Deadline 5 Submission

Written Representation Regarding Issue Specific Hearing 5 on Landscape and Visual Impact – Tuesday 13th July 2021

(Matters relating to Southern Park and Ride)

On behalf of Marlesford Parish Council Regarding NNB Generation Company (SZC) Limited DCO Application

**DRAWING TITLE:**  
SOUTHERN PARK AND RIDE  
PROPOSED LIGHTING AND CCTV PLAN  
SHEET 1 OF 5

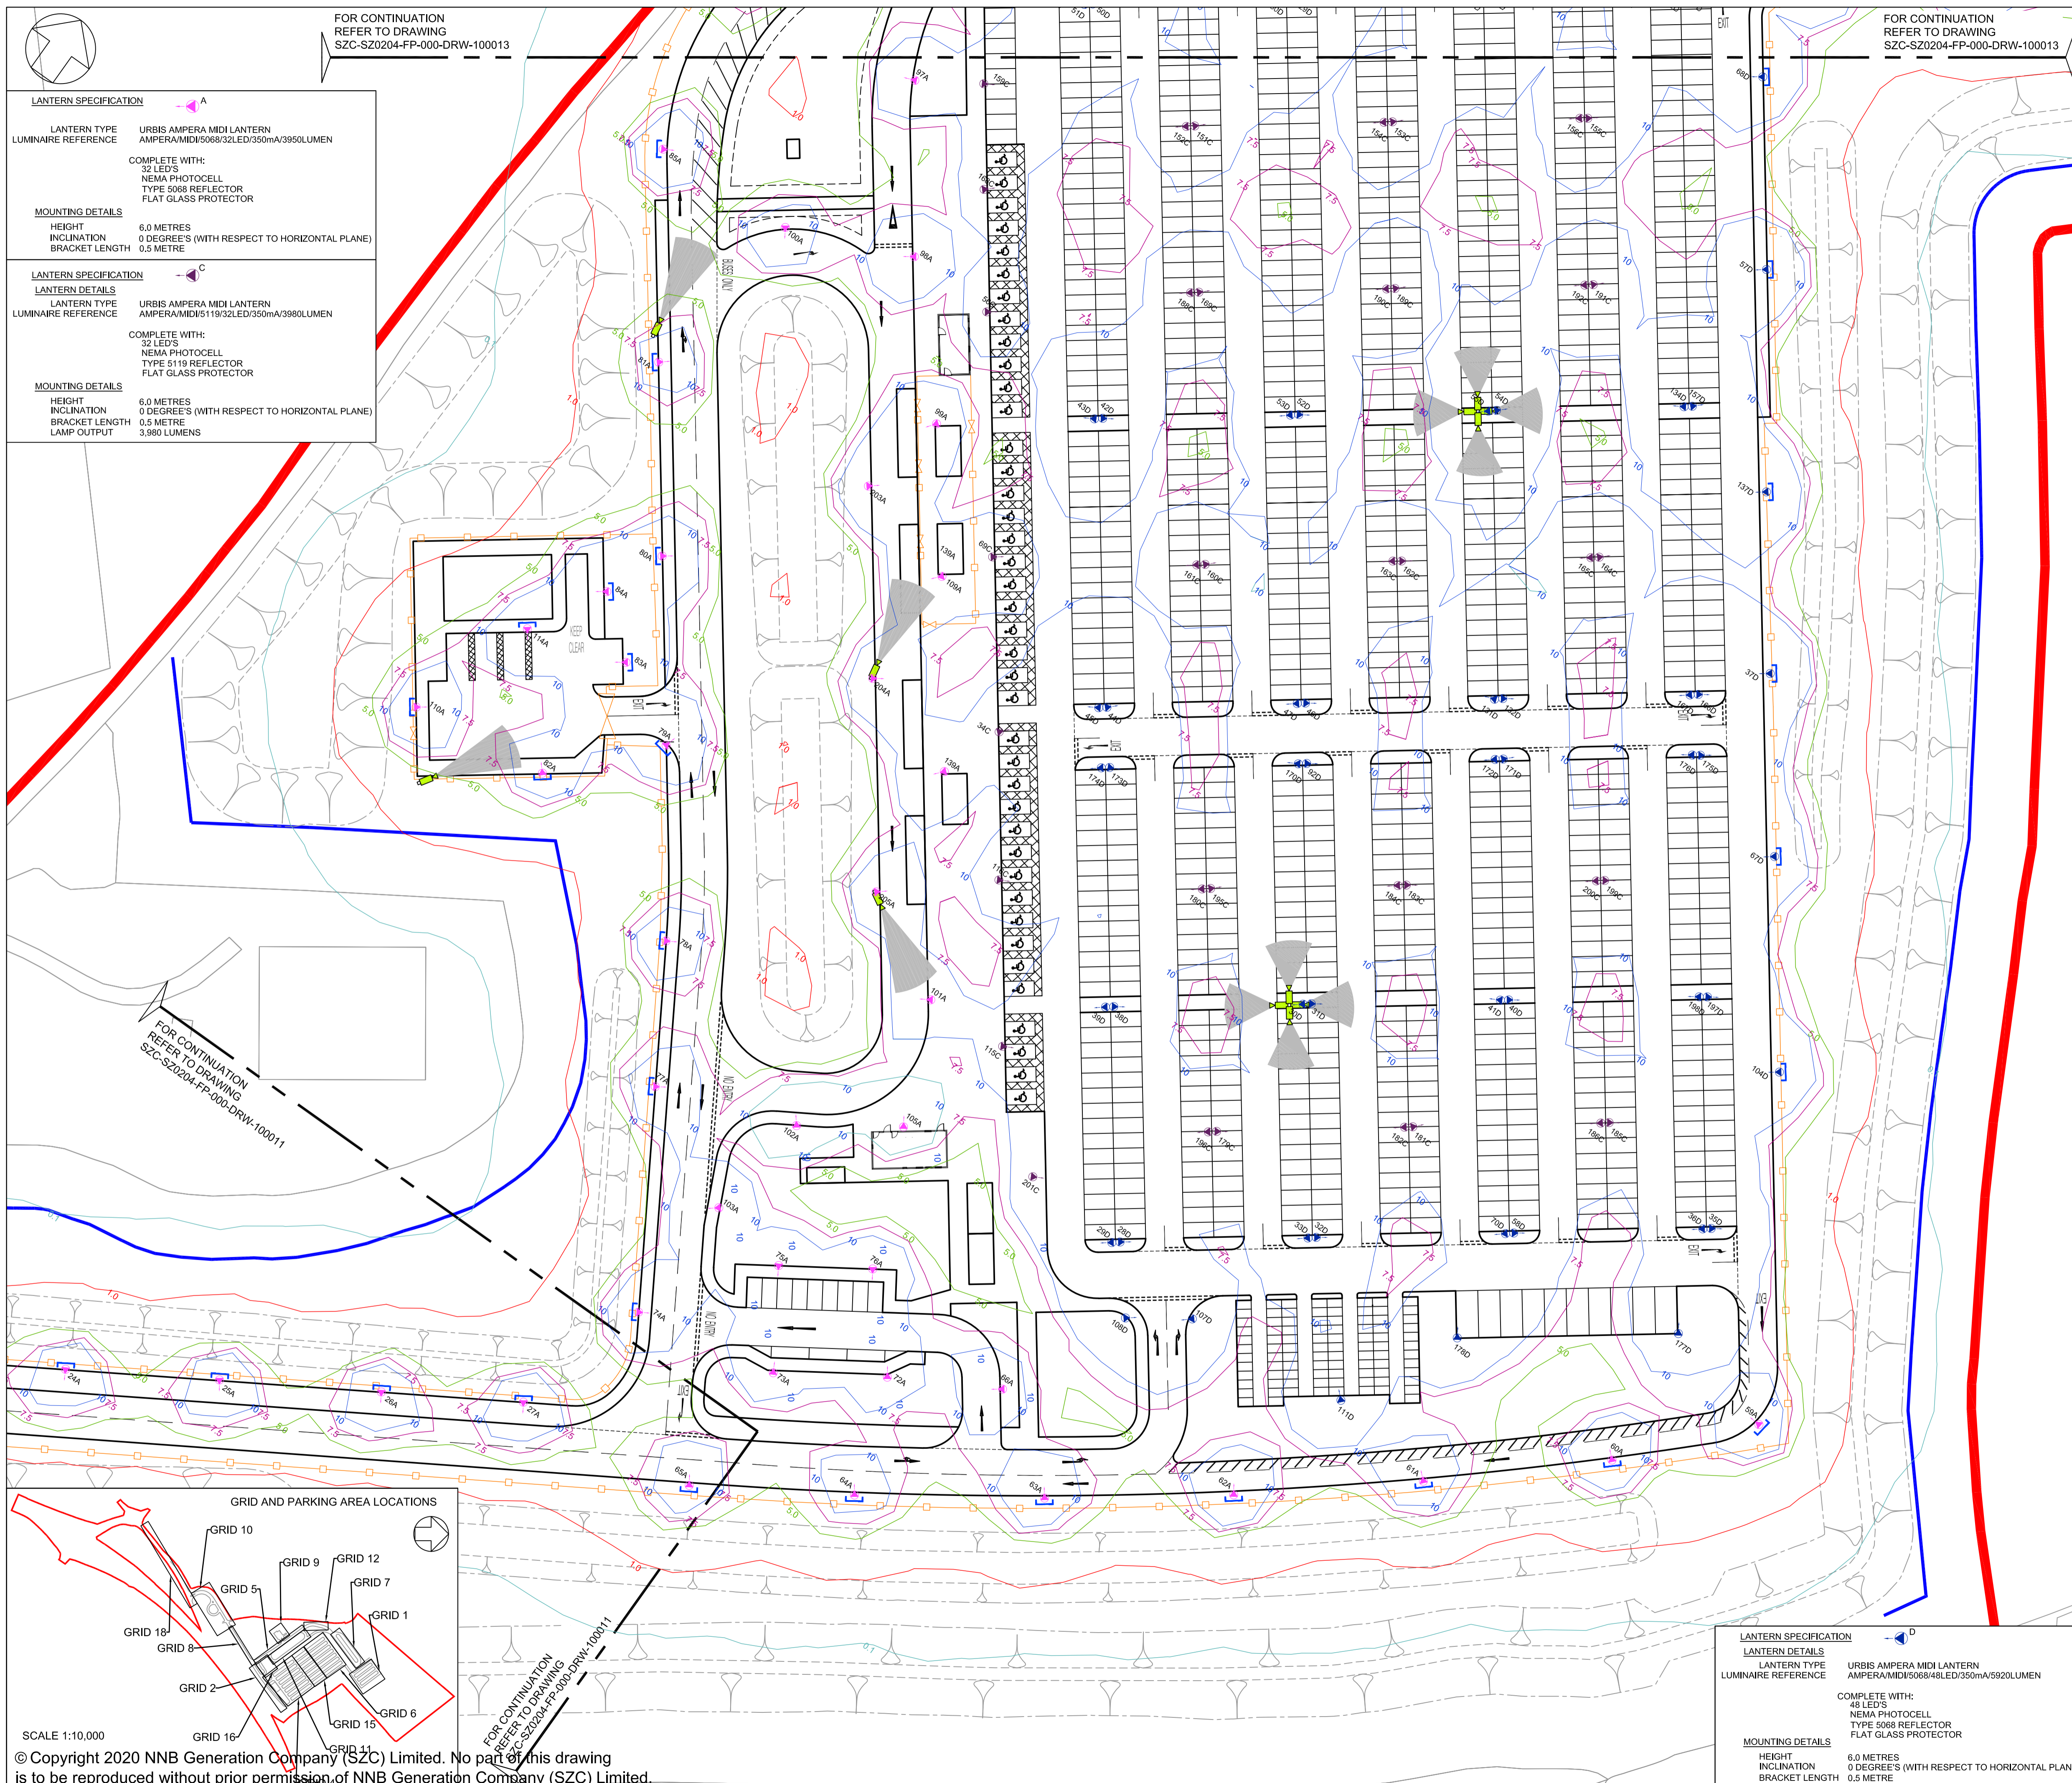
d.	Lighting	<p>The proposed site of the SP&R would introduce extensive areas of lighting into a landscape that, at the present time, is generally dark. Whilst not a designated dark skies area, residents of Marlesford and the surrounding villages value the relatively unpolluted night skies in an essentially rural area. We ask that the ExA make a night-time visit to the SP&R, viewpoints and surrounding villages in order to witness the dark skies enjoyed by them and to consider the likely impact of the SP&R lighting on dark skies.</p> <p>We are particularly concerned about light spill from the SP&R. We note that the surrounding bunds are in the main 3m high, but lighting columns within the site are 6m. We believe that this will result in widespread visibility of the SP&R at night because of its elevated position. We will request widespread use of low-level down-lit lighting (close to the ground) which we believe will achieve the required effect within the site but will be largely hidden (by the bund) from surrounding receptors.</p>

<p>We talk to contacts in Darsham who share our concerns about lighting. We understand that Darsham has a dark skies designation, but Marlesford argues that there should be no difference in the specification for the lighting between the Northern and Southern Park and Rides and every effort should be made by the Applicant to preserve the dark quality of the skies around the SP&R.</p> <p>The Applicant has indicated that the TIMA would not be lit when not in use. However, we have yet to see how the TIMA will be lit when it is in use. The TIMA is located on one of the highest parts of the site and when in use lighting would be particularly noticeable from points in the surrounding landscape, including the more rural parts such as the south-facing valley sides in Marlesford and the B1116 through Hacheston.</p> <p>We expect “smart management” to be applied to the SP&R lighting so that areas that are not in use can be switched off or dimmed. We need further details on the lighting and its impact in order to fully understand the effects on surrounding receptors, especially settlements where light glow is likely to be visible even if the physical elements of the proposed development are not.</p> <p>We draw the ExA’s attention to paras 2.5.14 – 2.5.17 in The Landscape Partnership’s review [REP1-149] where the impacts of lighting are considered.</p> <p>We would expect a full lighting management plan for the SP&R to be produced by the Applicant for consultation.</p>
